**Town & Country Planning Act 1990 (as amended)
Town & country Planning (Development Management Procedure) (England) Order 2015
Application for Planning Permission for Works or Extension to a Dwelling**

Development New roof with first floor accomodation, dormer to side elevation, porch to side elevation & single storey rear extension (revision to previously approved BR/305/17/HH).

Location 30 Mansfield Road Bognor Regis

EXISTING GROUND FLOOR PLAN

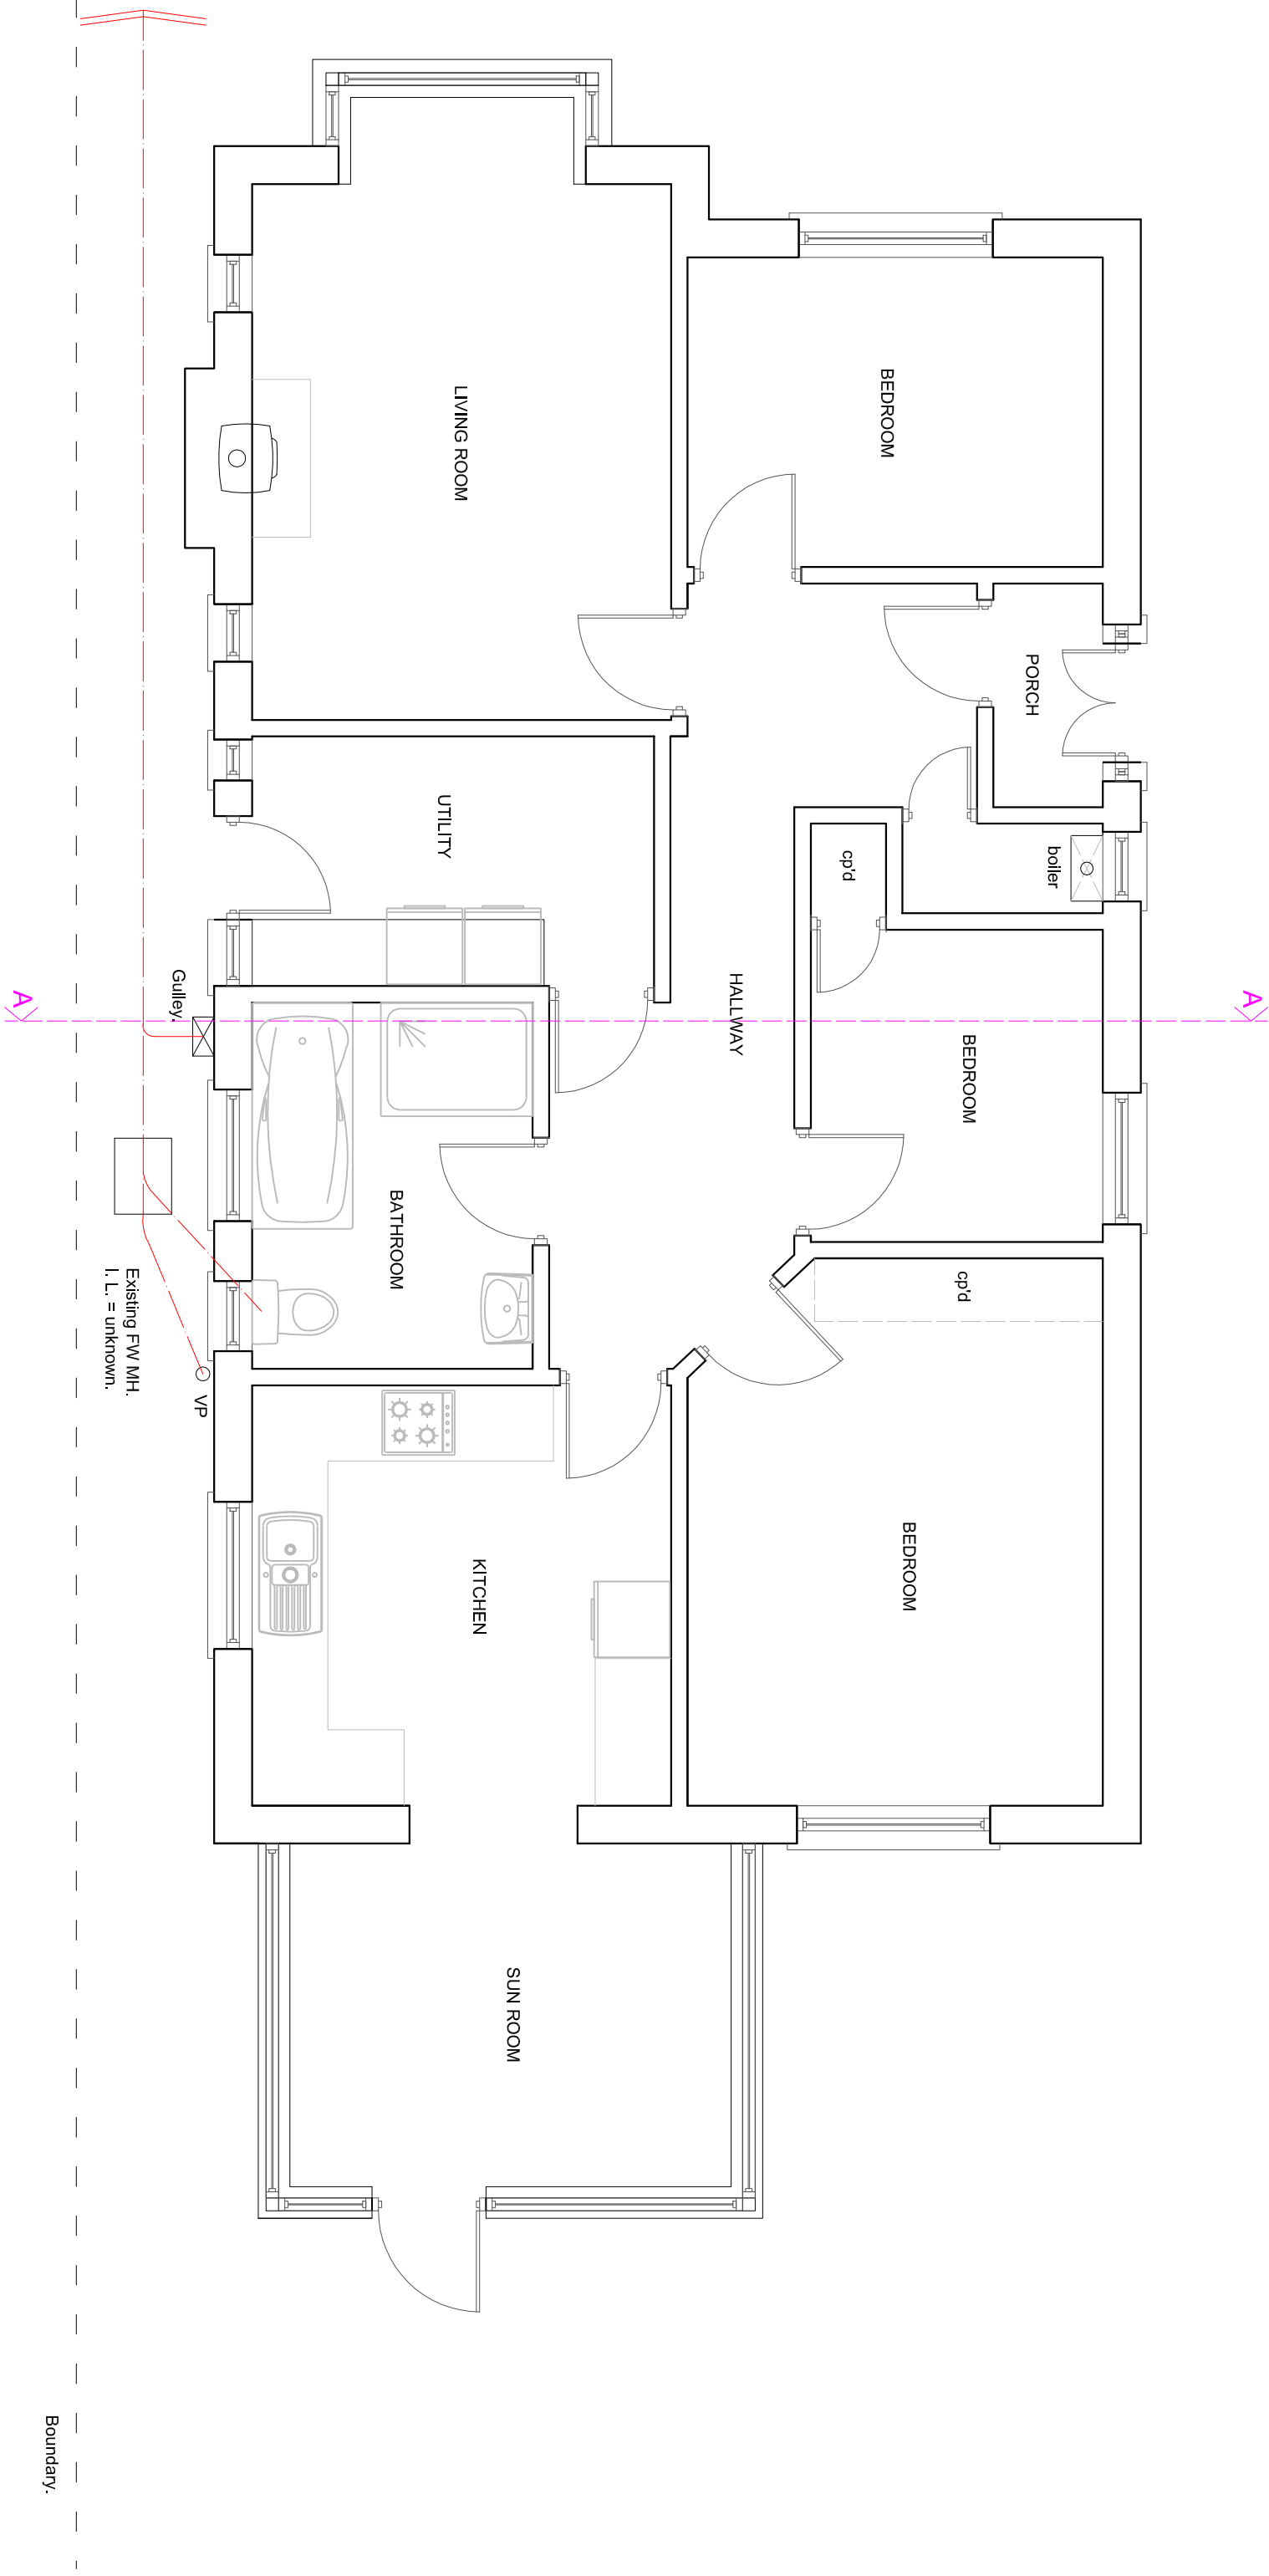
The existing and proposed ground floor plans and side elevations do not accord. Please amend accordingly.
